DRB CASE ACTION LOG

City of Albuquerque Planning Department Inter-Office Memorandum

Project # 1002562

The Environmental Planning Commission approved Project 1002562/03EPC 00487, Zone Map Amendment from R-1 & C-1 to SU-1 for a C-1 Permissive Uses and a Contractor's Yard, 03EPC 00488, Site Development Plan for Subdivision, 03EPC 00489, Site Development Plan for Building Permit on May 16, 2003. The applicant has not satisfied all of the conditions of approval for the approved site development plan for building permit.

ZONE CHANGE REQUEST
 MR. DALE KNIGHTON
 SHEET 1
 JUNE, 2003 ZONE ATLAS F-15

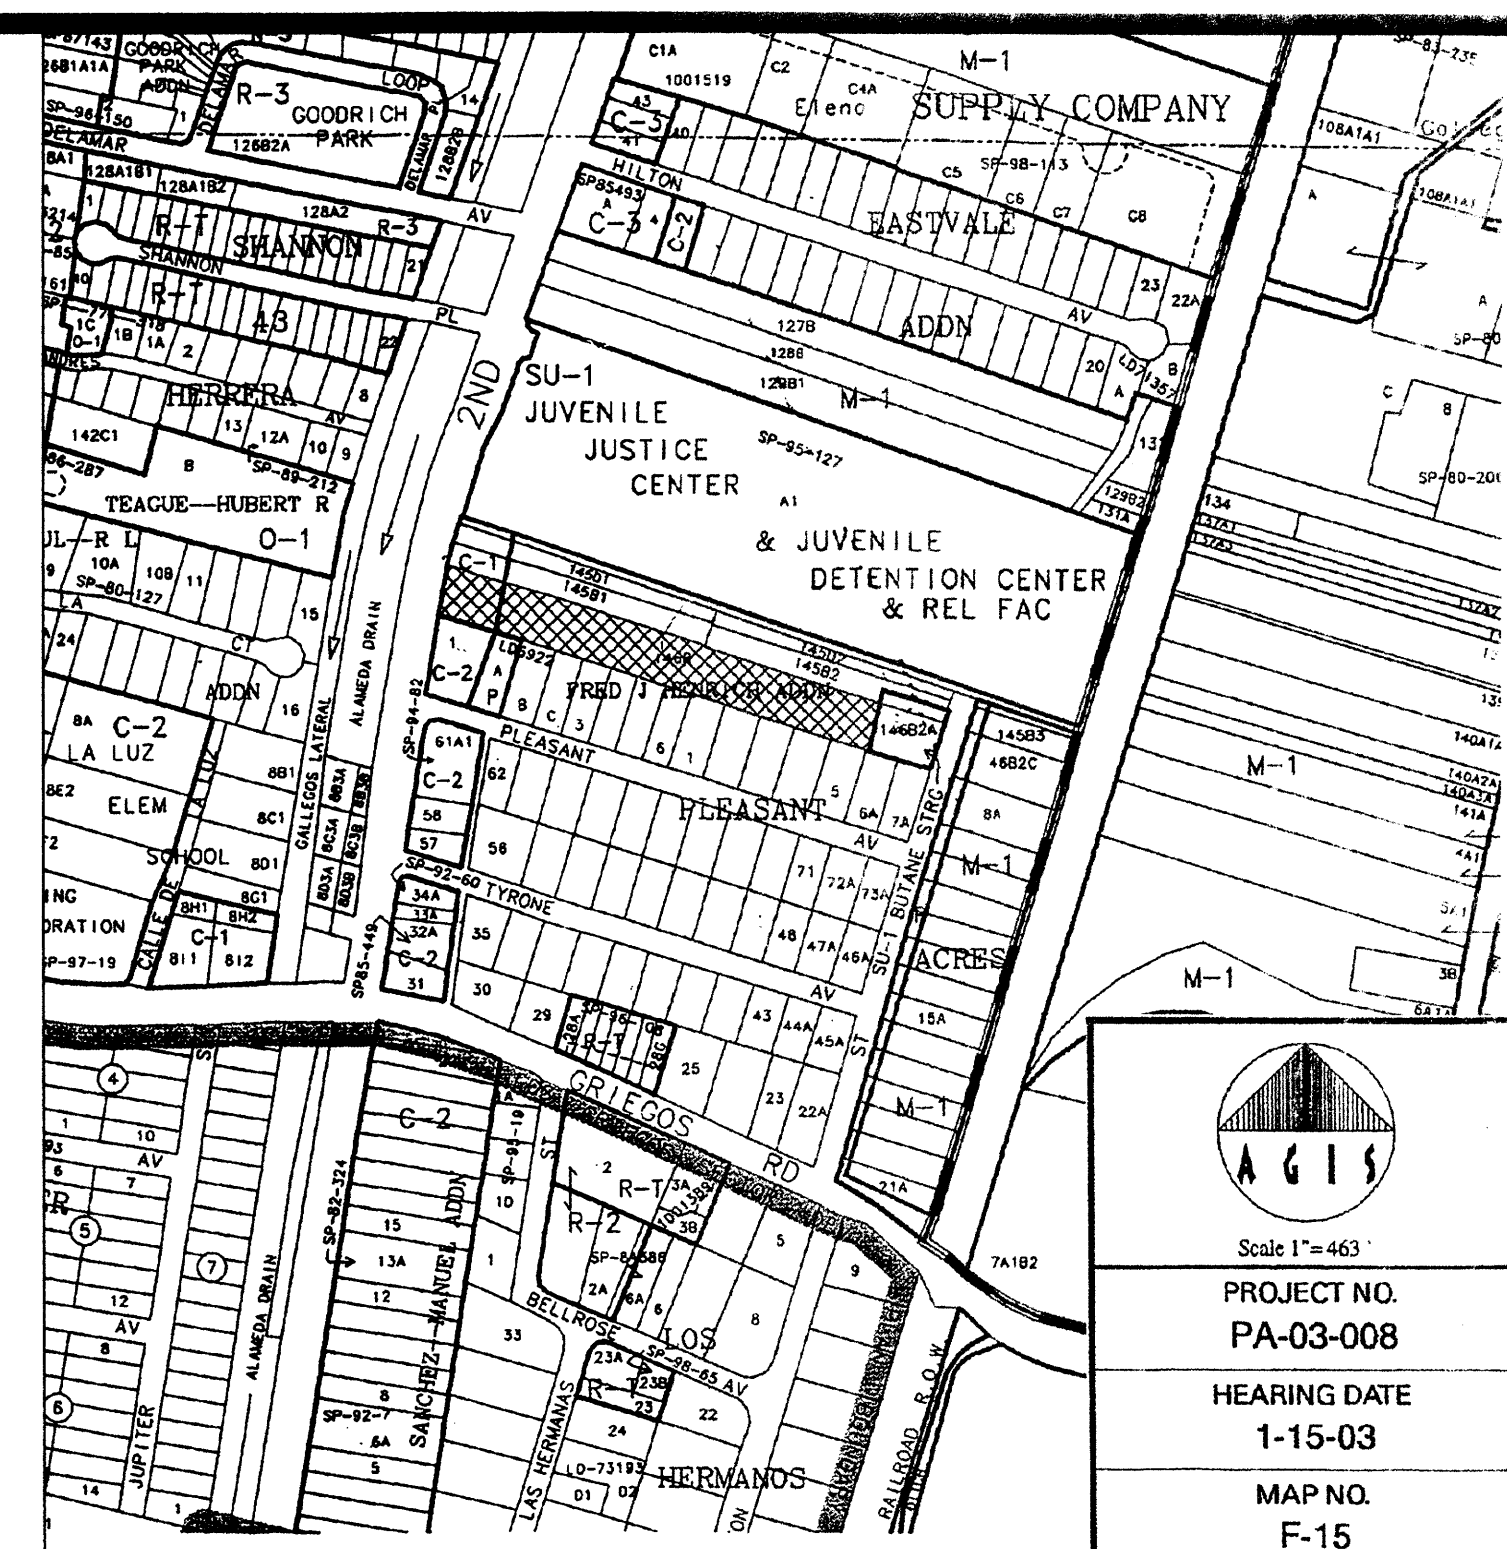
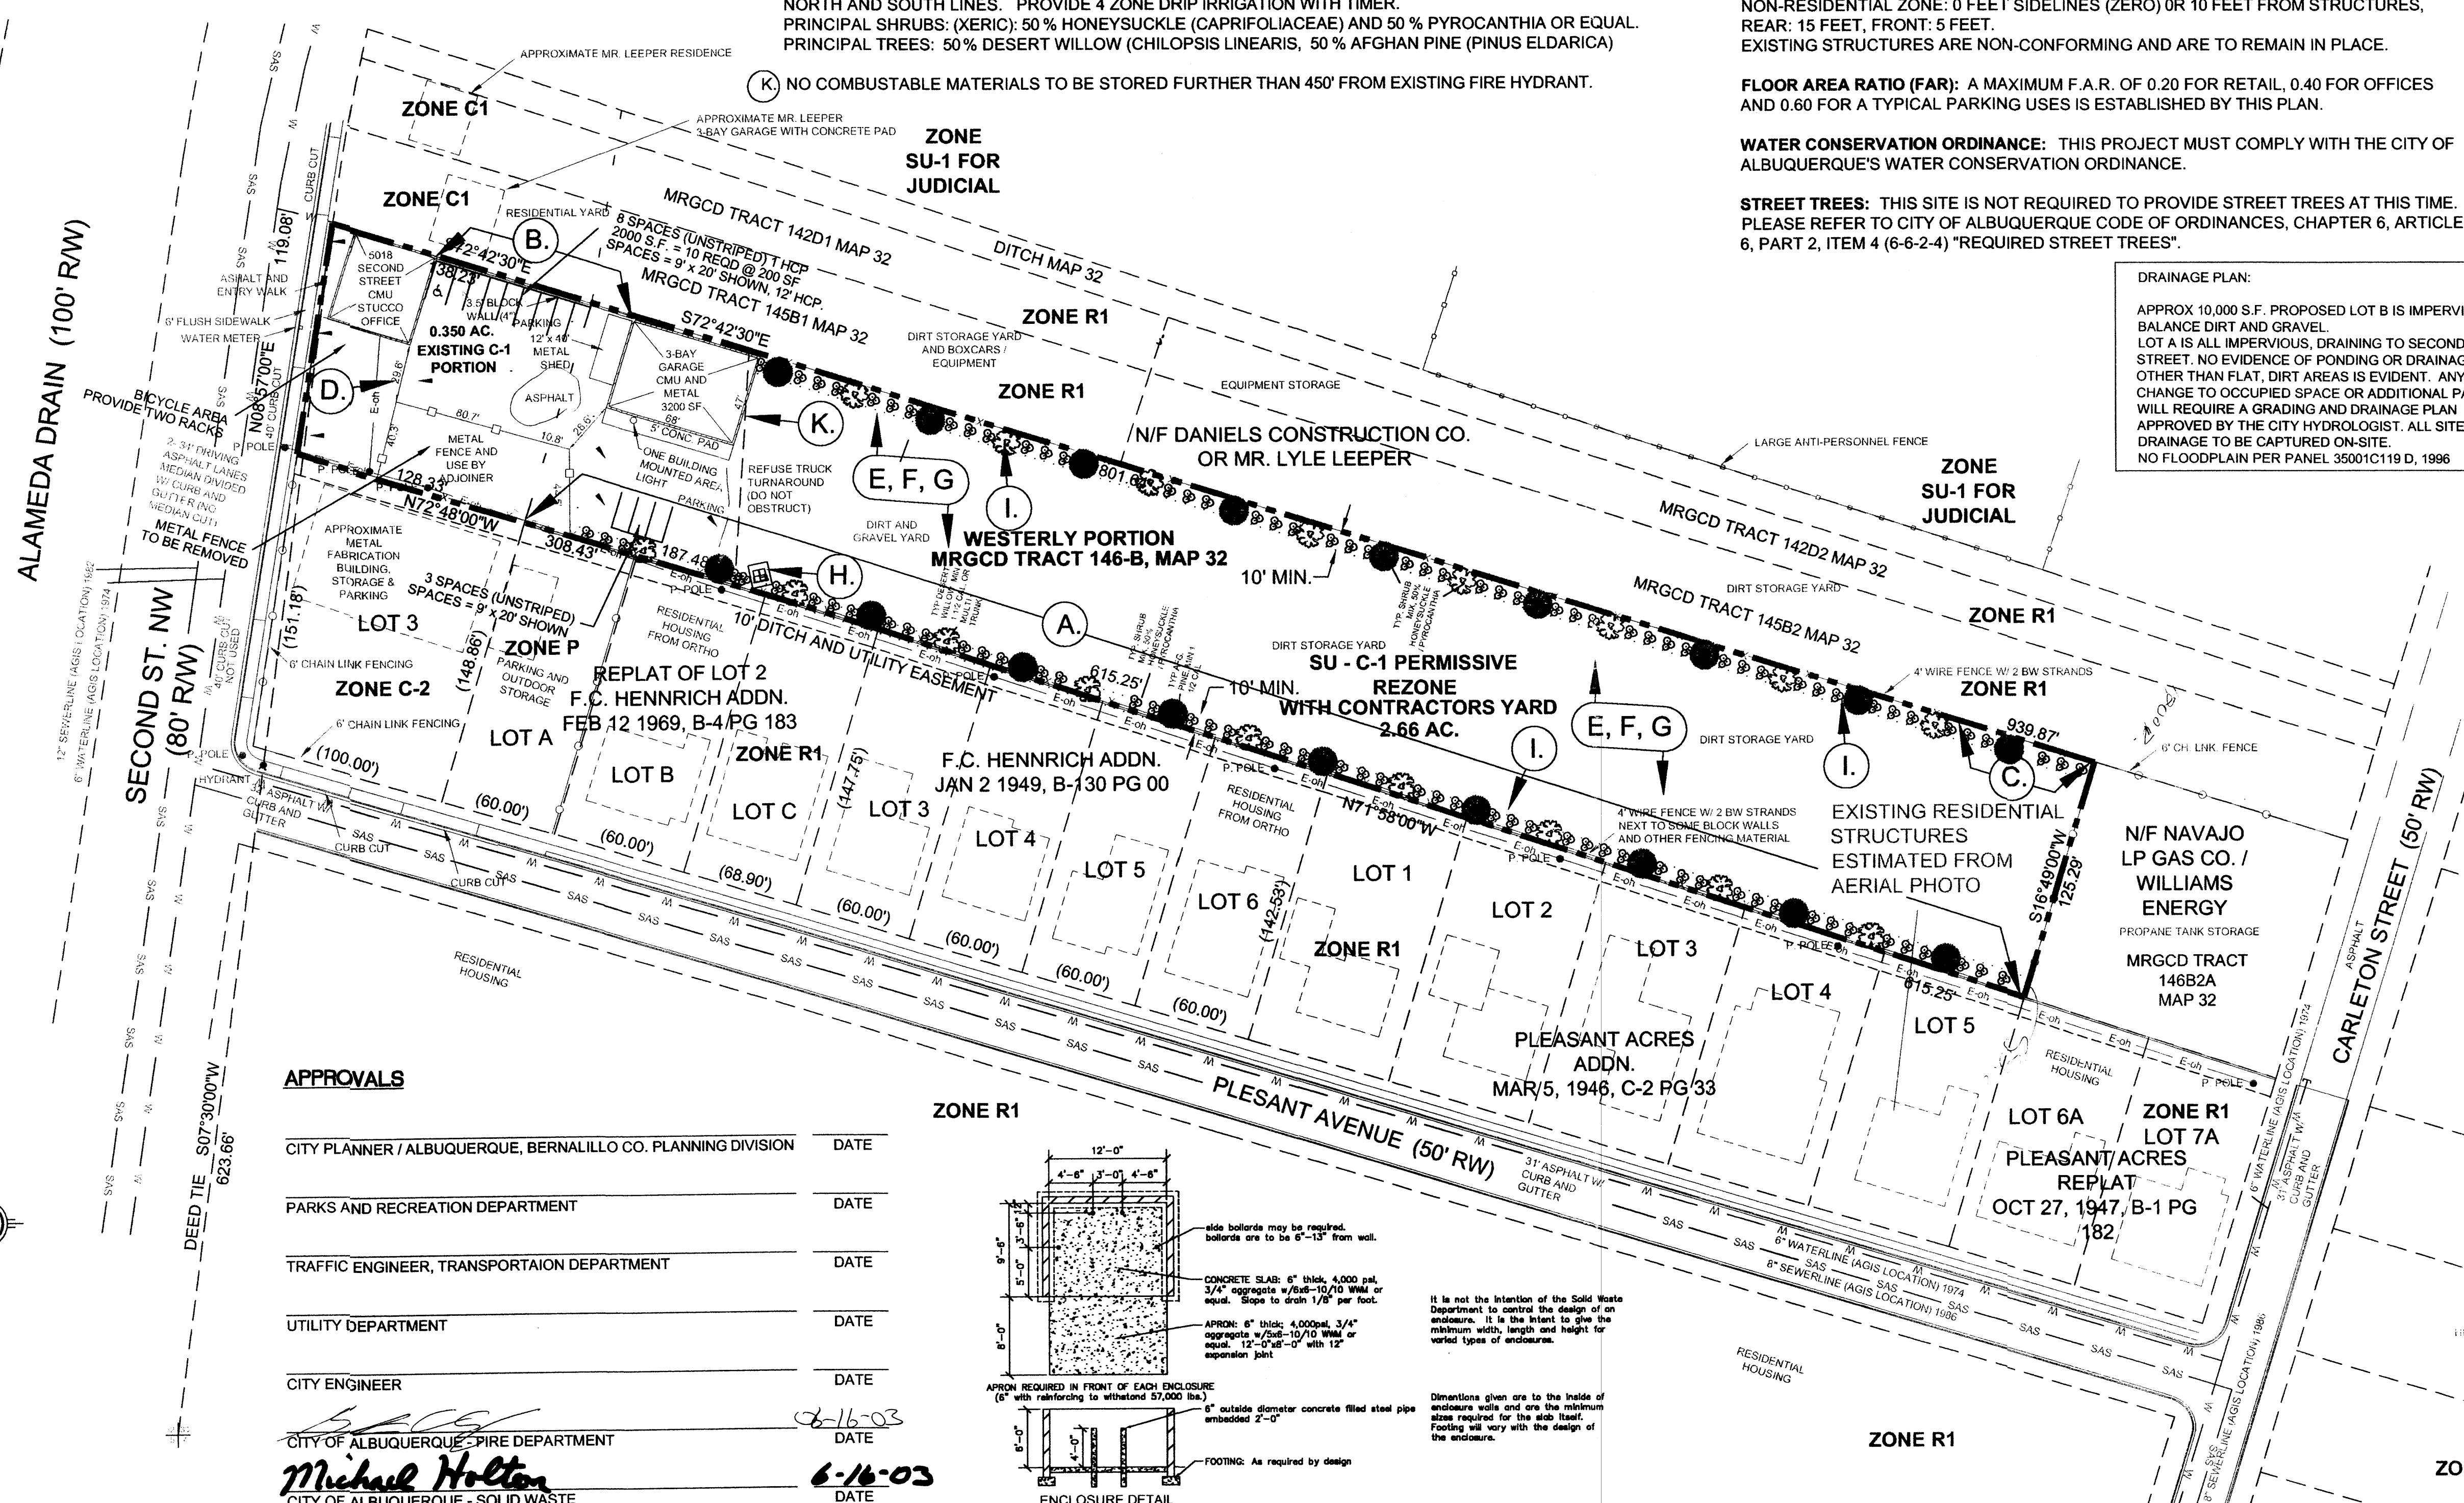
Off-Street Parking does not specify the type of paving.

2. All off-street parking is required to be paved parking.

All off-street parking is required to be striped.— Remove Site Flan Luns haped

The applicant does not provide an illustration of the bike rack.

5. Number of bicycle spaces is not specified.

1.) A-6' Landscape Buffer is required between the off-street parking spaces and the north property line as specified in Section 14-16-3-10(E)(3) of the Comprehensive

A 10' landscape buffer is required along 2nd St NW as specified in Section 14-16-3-10(E)(3).

Per the condition of approval, the applicant is required to install Street Trees along 2nd Street as regulated in the Street Tree Ordinance. This site is zoned SU-1 and EPC has utilized its authority to require additional landscaping.

The submittal does not contain landscaping calculations and a notation that 75%. of the area will be living ground cover.

5howing 5. The maintenance party must be specified on the submittal.

6. The submittal does not include dimensions of all the landscaped areas.

Under the "Landscaping" general notes, the third sentence needs to be removed. The applicant is required to provide large trees along the north property line.
